Our Ref: 66504/LT/001

29th October 2019

**Former Shredded Wheat Site, Broadwater Road,
Welwyn Garden City, AL8 6UN**

Please see below Curtins responses to comments made by Julia Puton of Hertford County Council in her letter dated 30th August 2019.

Dwg Title: **PROPOSED DRAINAGE DETAILS SHEET 3**

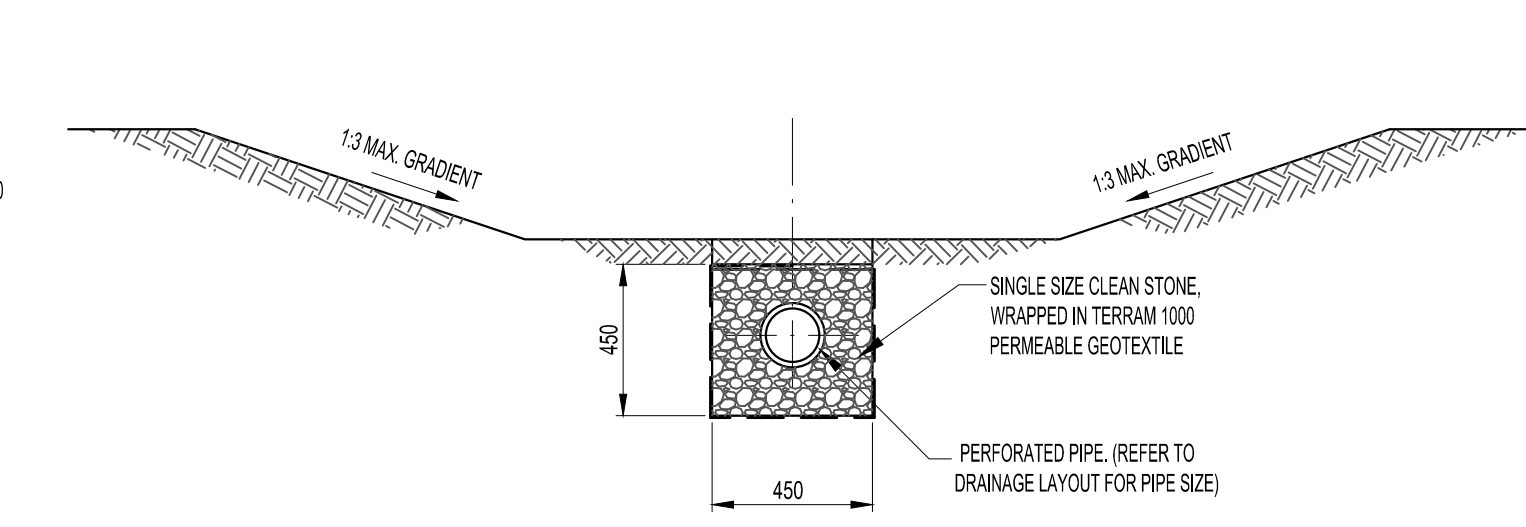
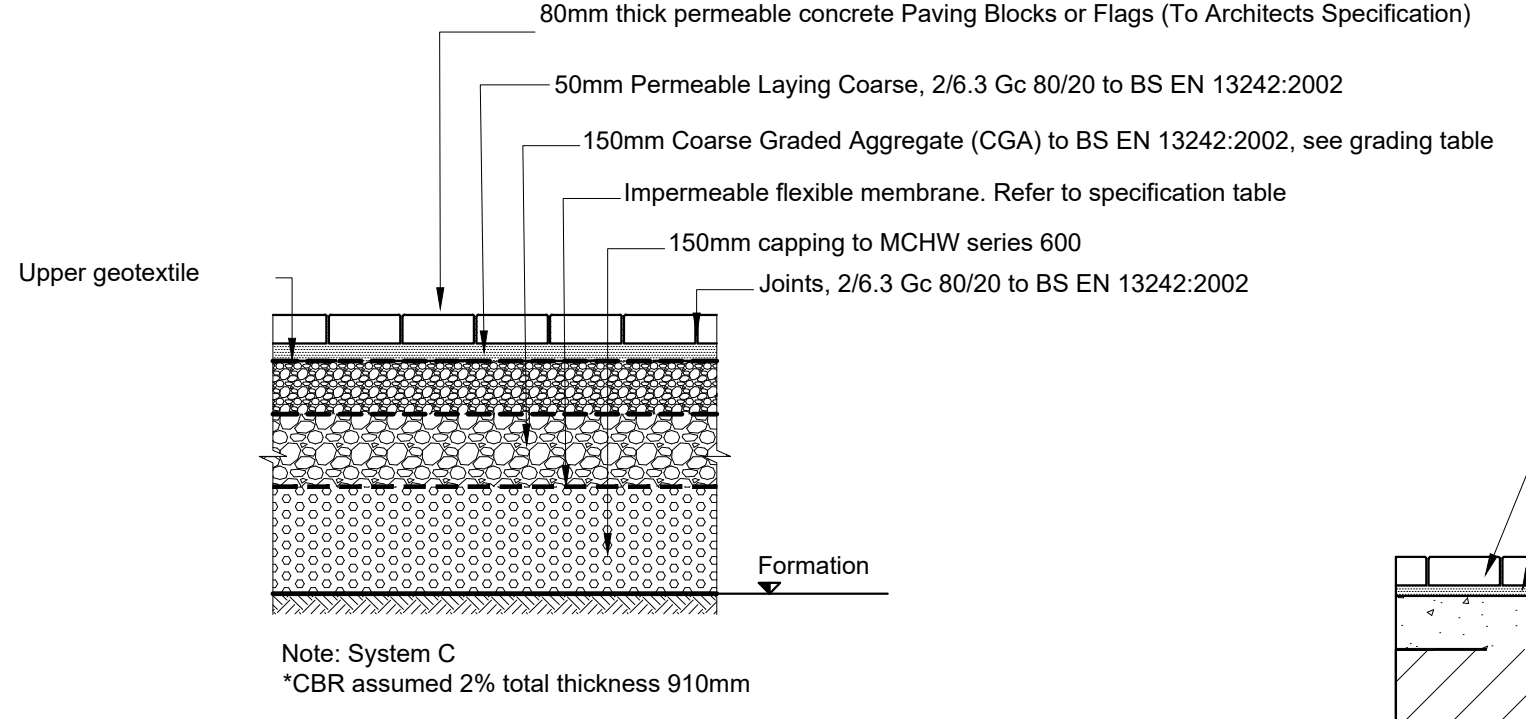
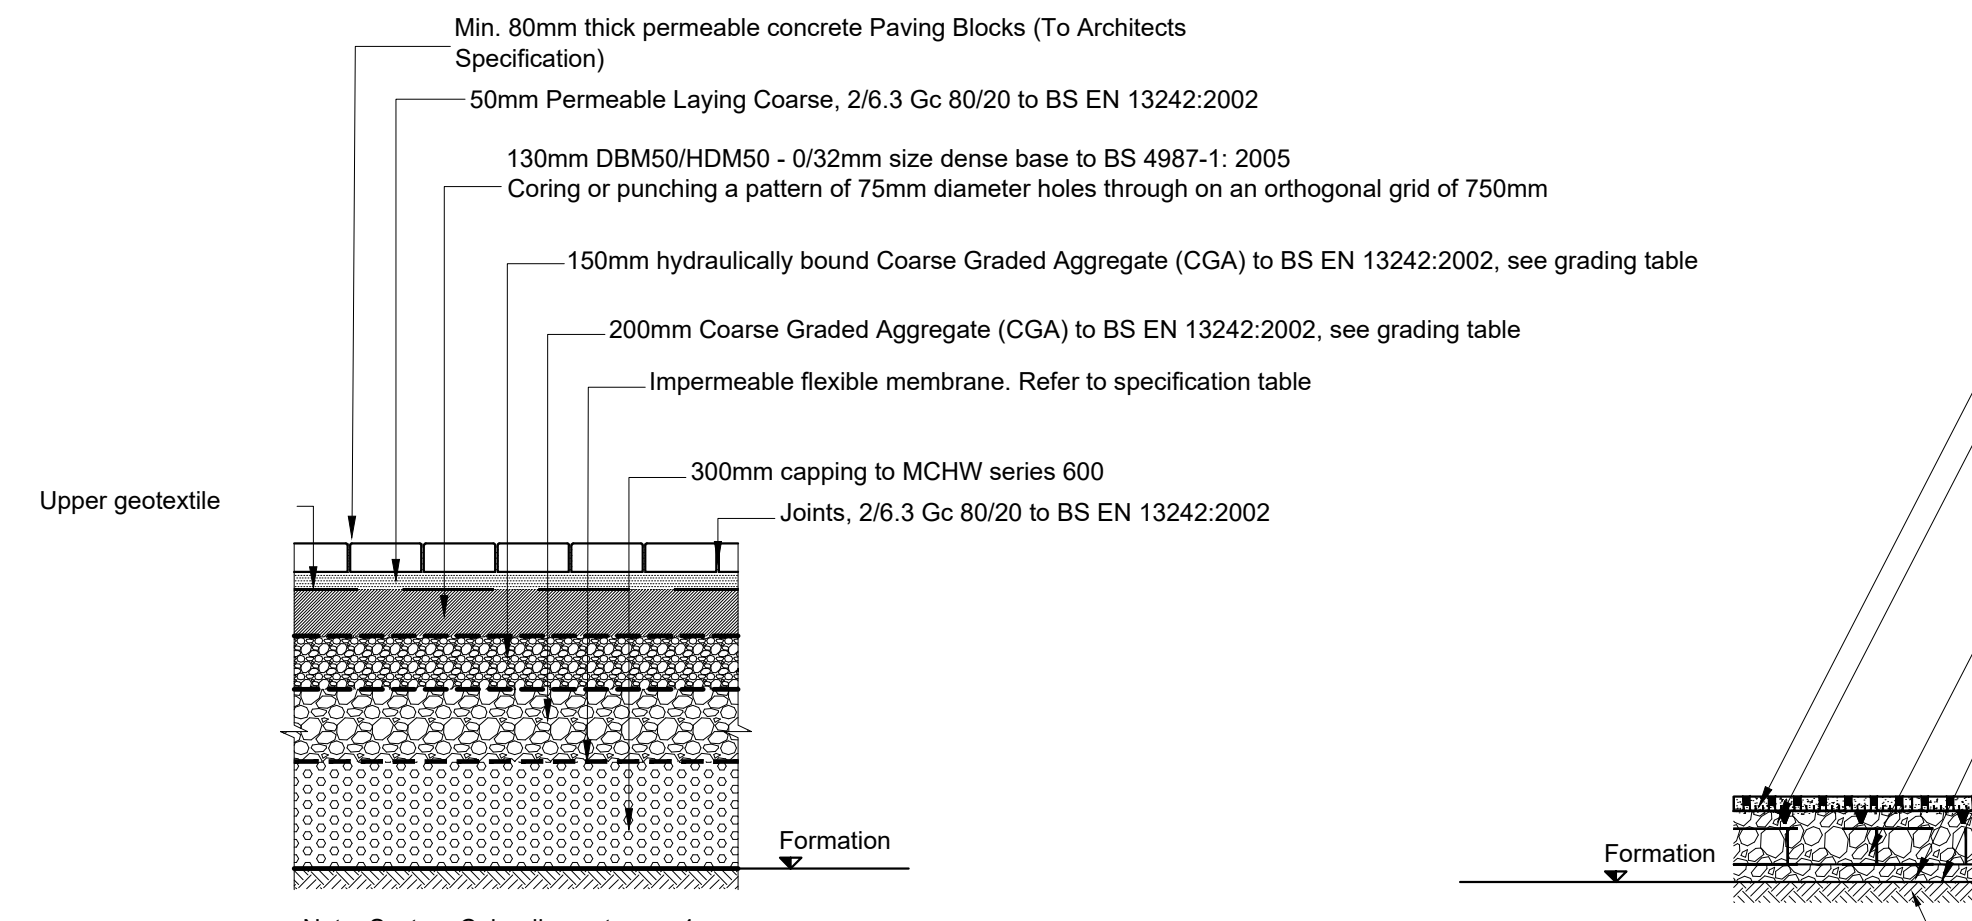
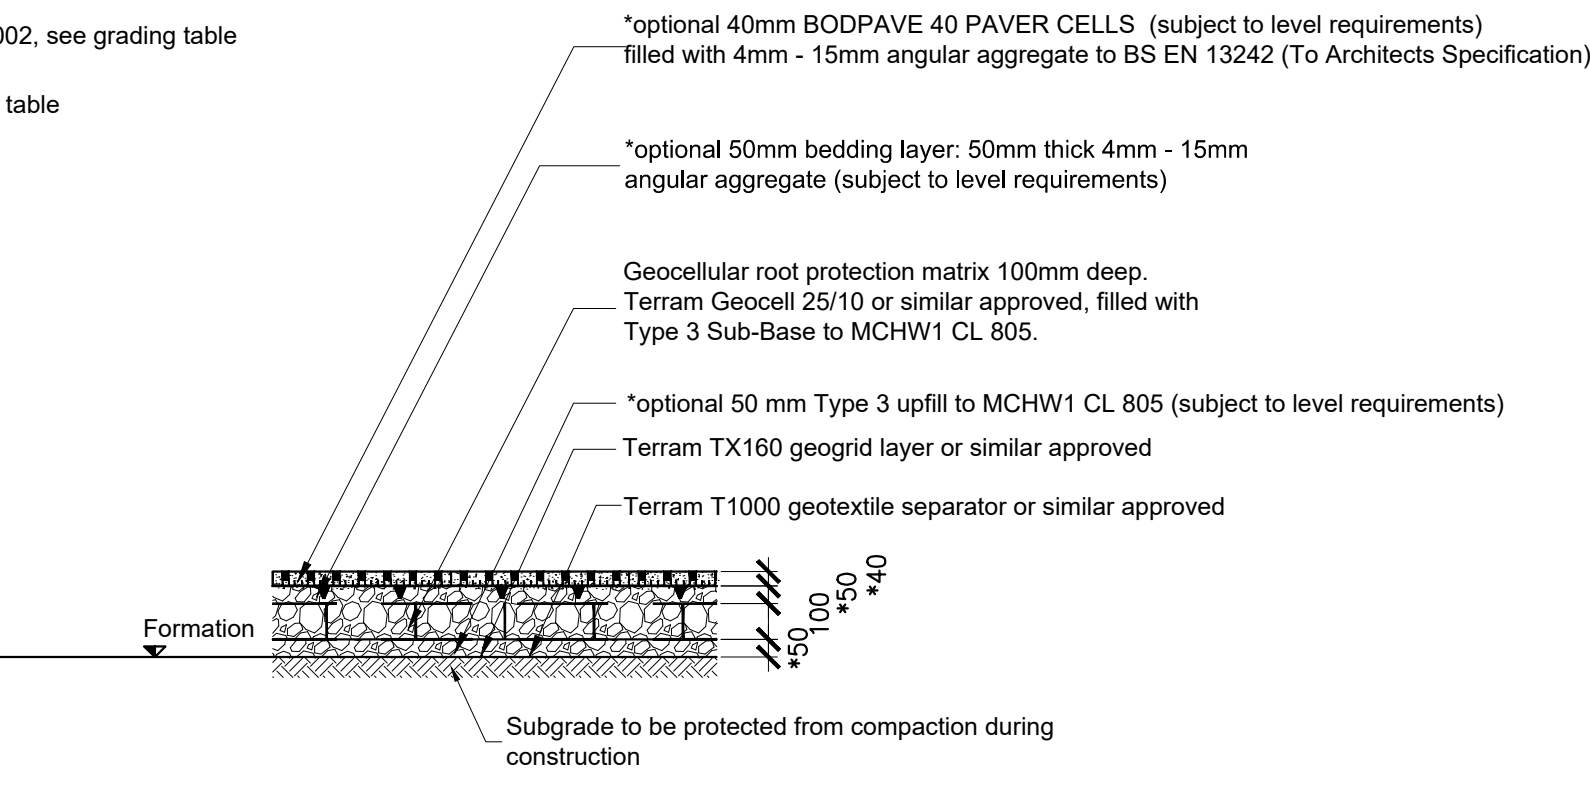
4. Full detailed engineering drawings including cross and long sections, location, size, volume, depth and any inlet and outlet features. This should be supported by a clearly labelled drainage layout plan showing pipe networks. The plan should show any pipe 'node numbers' that have been referred to in network calculations and it should also show invert and cover levels of manholes. Total storage volumes provided within each future sub-catchment should be identified.

6. Silt traps for protection for any residual tanked elements.

*Engineering details shown on the following drawings. Refer to Drawings:
066571-CUR-00-00-DR-C-90003 PROPOSED DRAINAGE LAYOUT (PHASE 1)
066571-CUR-00-00-DR-C-90001 SITE WIDE
066571-CUR-00-XX-DR-C-98001 PROPOSED DRAINAGE DETAILS SHEET 1
066571-CUR-00-XX-DR-C-98002 PROPOSED DRAINAGE DETAILS SHEET 2
066571-CUR-00-XX-DR-C-98003 PROPOSED DRAINAGE DETAILS SHEET 3
Drainage strategy 061731-CUR-00-XX-RP-S-001.*

*Refer to Drawing 066571-CUR-00-00-DR-C-90003 "PROPOSED DRAINAGE LAYOUT (PHASE 1)
Catchpit manholes provided at each attenuation tank. Baffle plates to be included where required.*
